COUNTY COUNCIL'S RESPONSE TO CONSULTATION ON THE FOLLOWING DEVELOPMENT PROPOSAL

Application no: 16/02446/F-2

Proposal: Erection of 296 residential dwellings (Use Class C3) comprising a mix of open market and affordable housing, together with associated works including provision of new and amended vehicular and pedestrian accesses, public open space, landscaping, utilities and infrastructure, and demolition of existing built structures and site clearance works

Location: Heyford Park, Camp Road, Upper Heyford, Bicester, OX25 5HD.

DETAILS  
PHASE 9 S278 GENERAL ARRANGEMENT

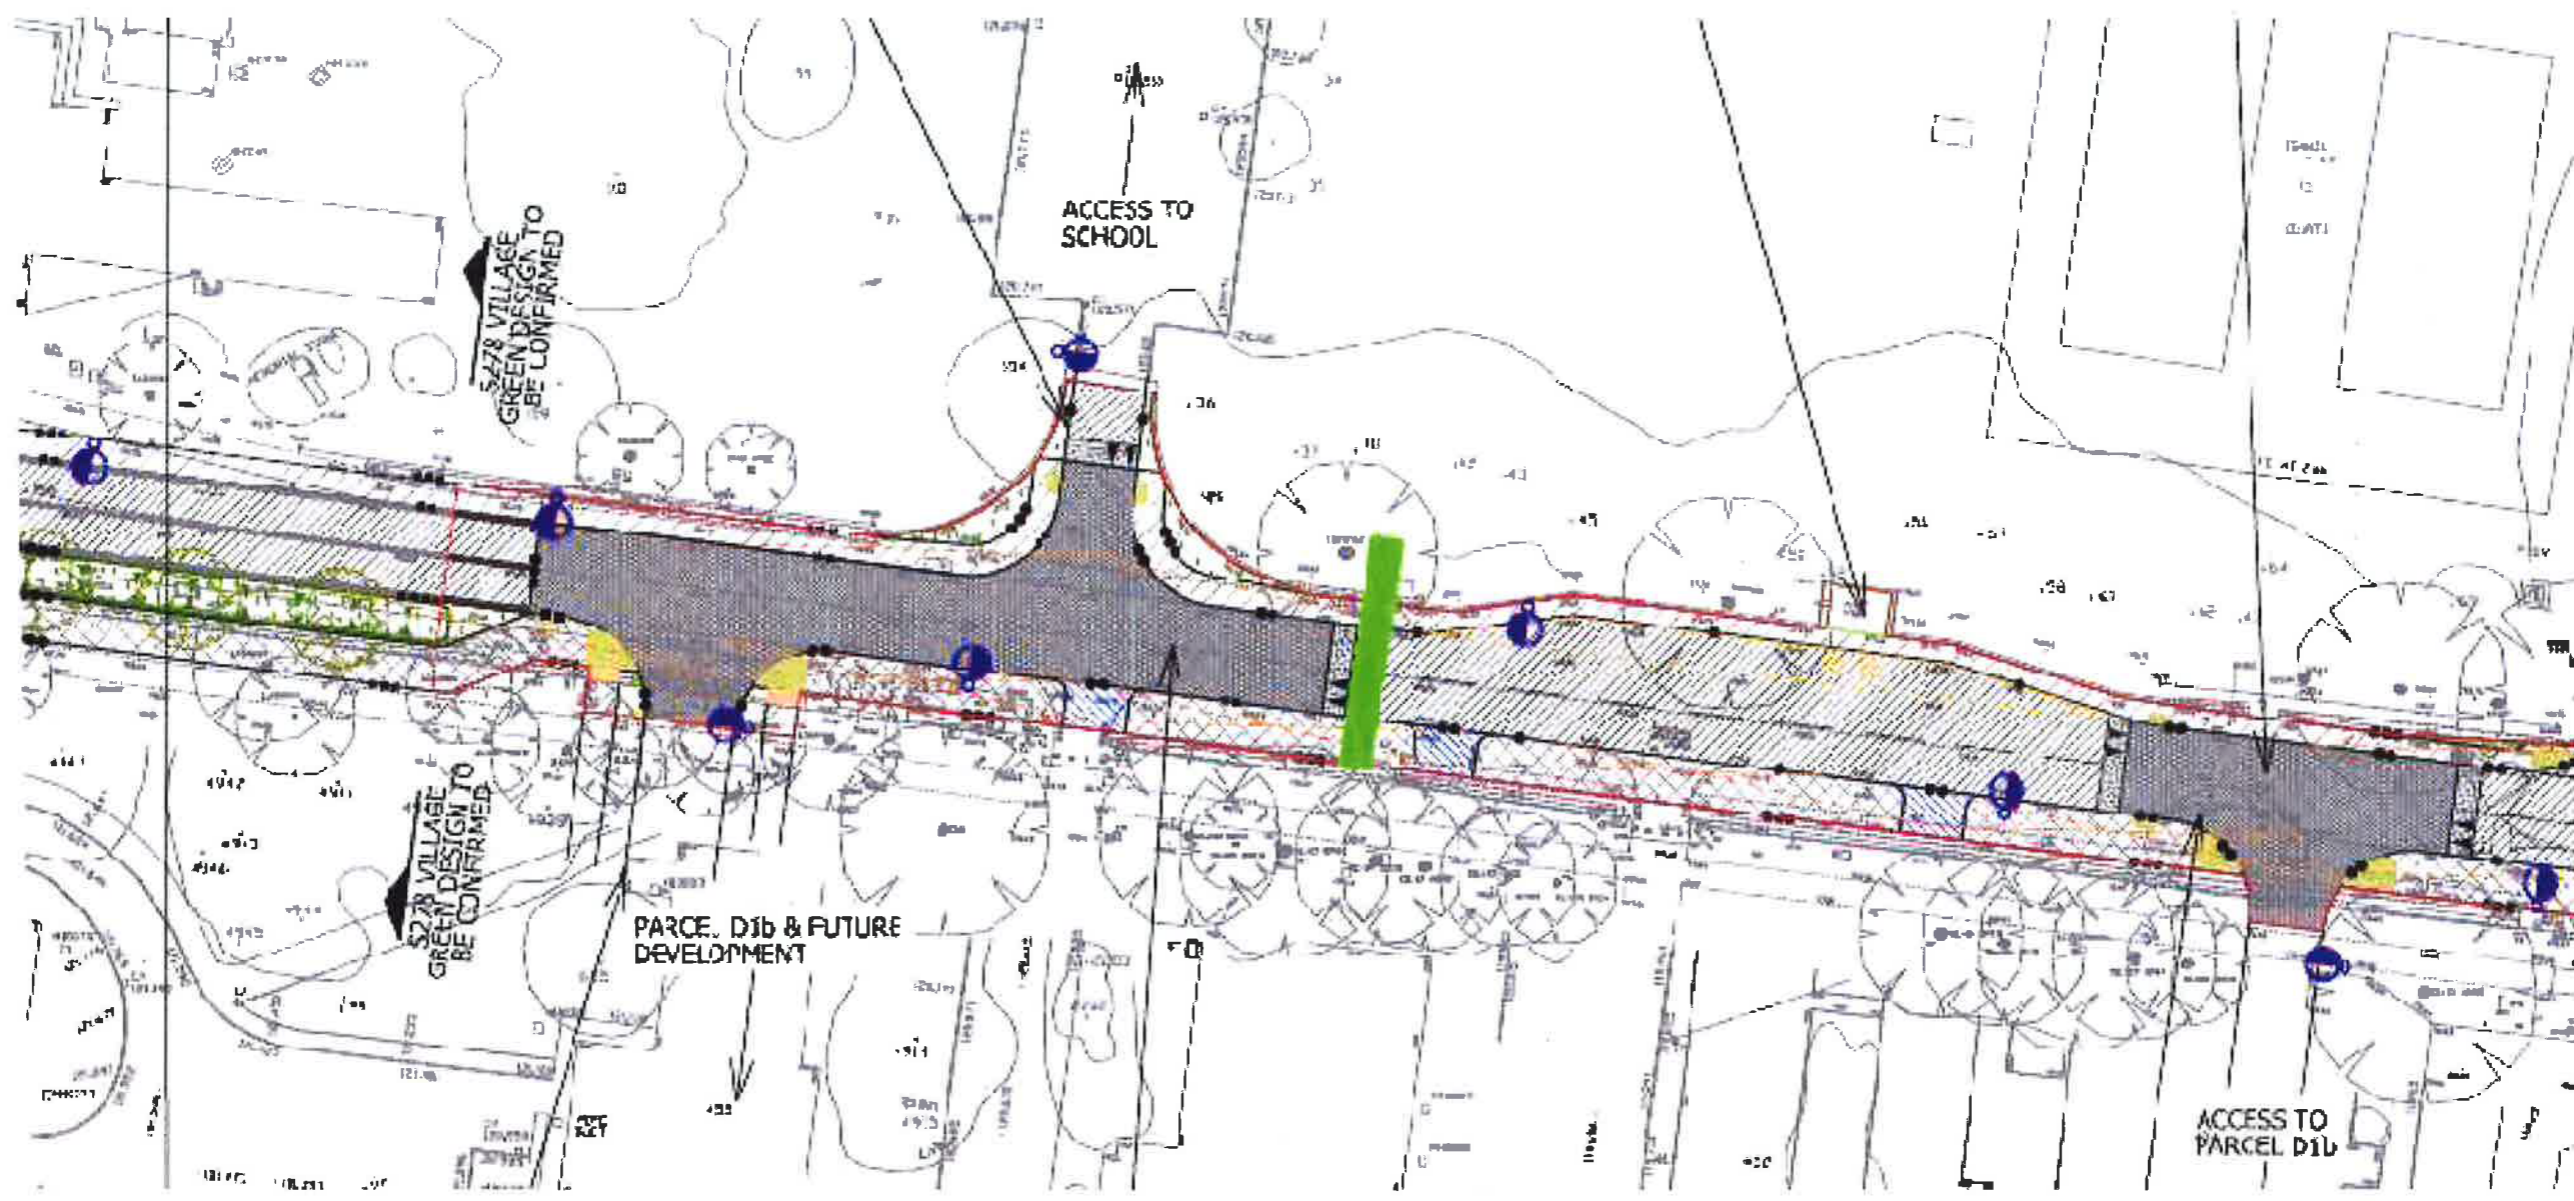
26. Visibility splays at site access junctions. Visibility splays of 2.4 x 70m are shown onto Camp Road, which I consider to be acceptable given that Camp Road is/will be traffic calmed. However, some of these splays will require removal of parts of the hedge. It is noted that the land between the proposed footway and Camp Road, including the hedge, is intended to be dedicated as highway. Any S278 agreement will require adequate clearance of hedge. These accesses must be laid out and appropriate visibility splays cleared prior to first use.

Parameter Plan D.0358_04 (Pegasus)

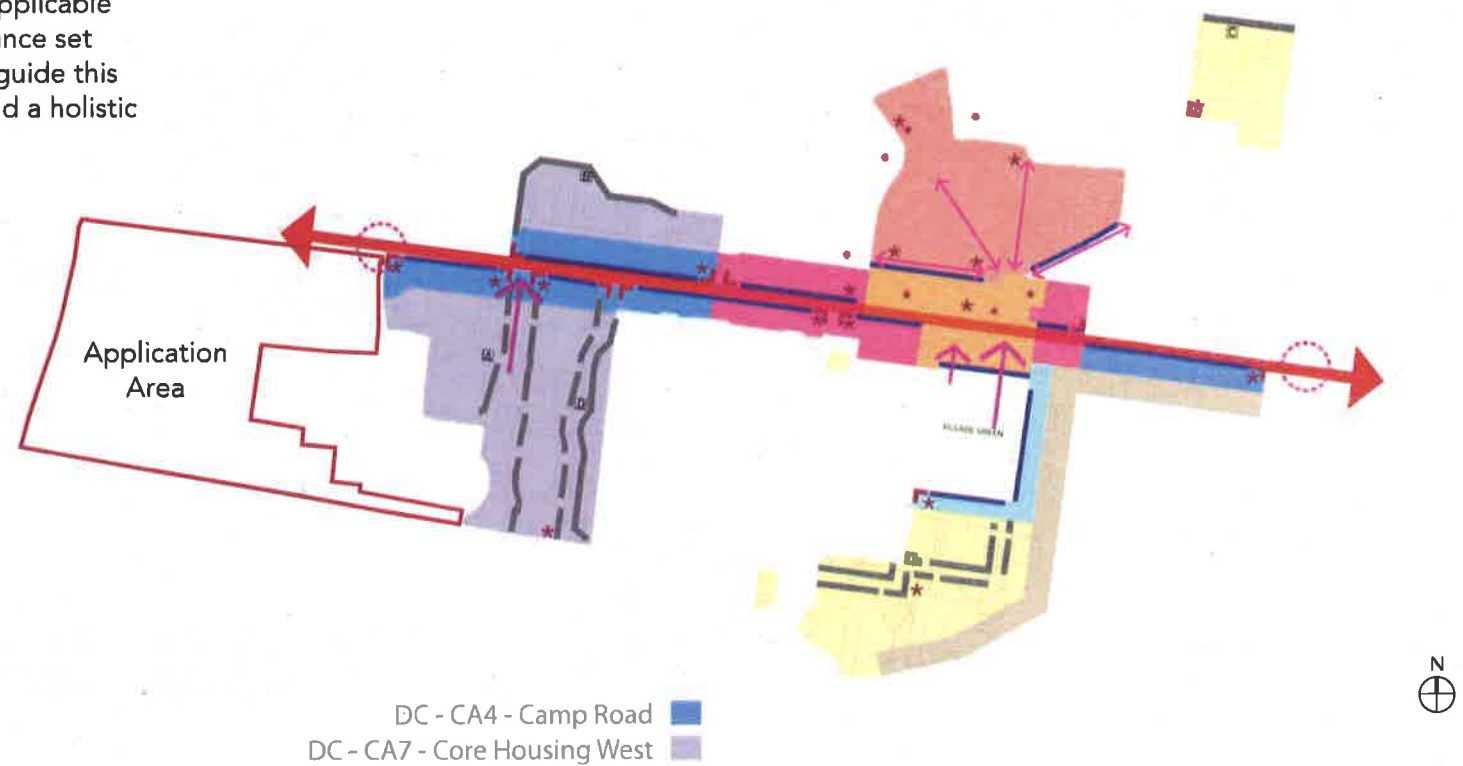
18. Portway bridleway works: The layout now shows the route through the site, taking into account OCC's comments, but some further detail is necessary and could be required by condition. It is understood the bridleway will be permissive and managed as part of the open space. The access points need to be marked on the Parameter Plan.

19. Lack of footpath connection to the south east corner of the site: A footpath to the boundary is shown on the planning layout. However, the Parameter Plan should be updated to show this as a pedestrian access point. There needs to be a firm commitment to provide gated access at the boundary here. Likewise, the northern and southern access point of the bridleway/footpath along the western edge of the site onto the adjacent roads needs to be marked on the parameter plan.
